CITY OF ALBUQUERQUE

April 27, 2018

**Re: Pizza Hut – 303 Coors Blvd NW
Erosion and Sediment Control Plan
Engineer's Stamp Date 4-12-18 (K10E020D)**

PIZZA HUT HUBBEL PLAZA		DRAWN BY DY
	TEMPORARY EROSION CONTROL AND SEDIMENTATION PLAN		DATE 2/22/18
	 TERRA WEST, LLC 5571 MIDWAY PARK PLACE NE ALBUQUERQUE, NM 87109 (505) 858-3100 www.tierrawestllc.com		2017015-SWPPP
			SHEET # EC-1 JOB # 2017015

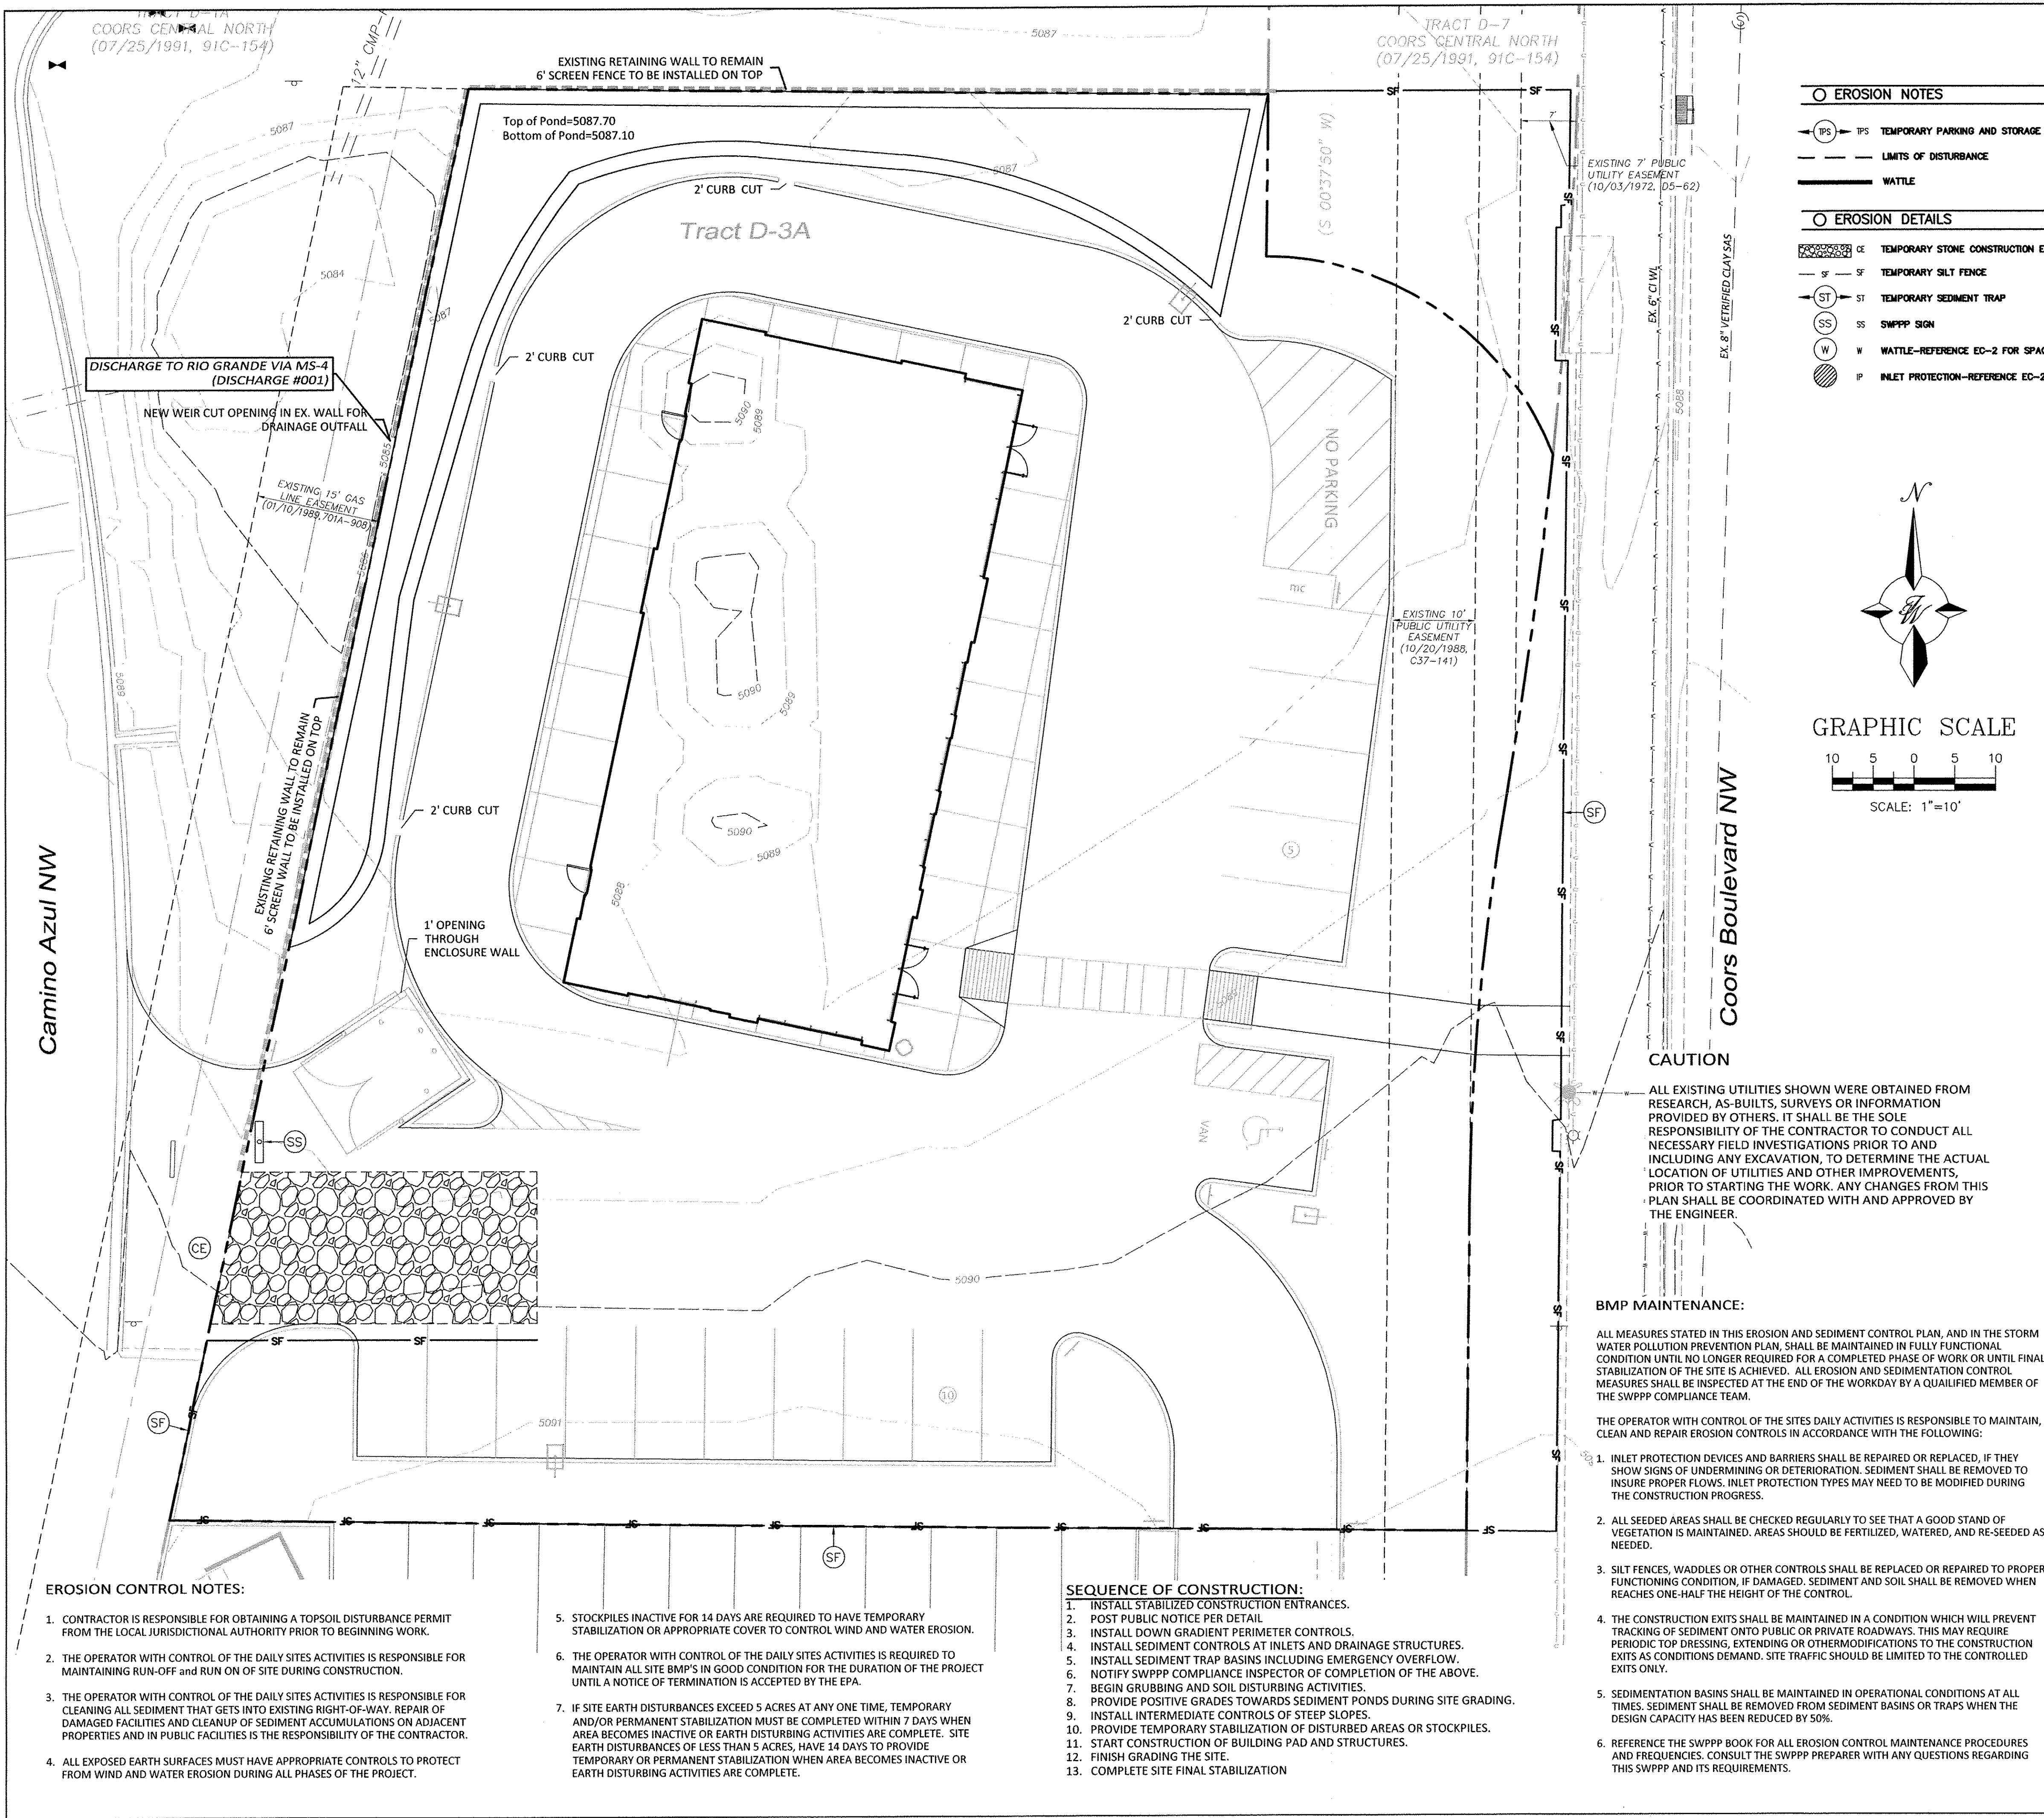
1. The silt fence along the southern edge of the project is proposed on top of asphalt. Silt fence will not seal on an impervious surface. If the asphalt is to be removed prior to the installation of the silt fence, then it is acceptable as long as grading of the site has not occurred prior to BMP installation.

2. Show proposed grades.

3. It is not clear that silt fence is proposed along the northern and western edges (north of the Construction Ordinance) of the site.
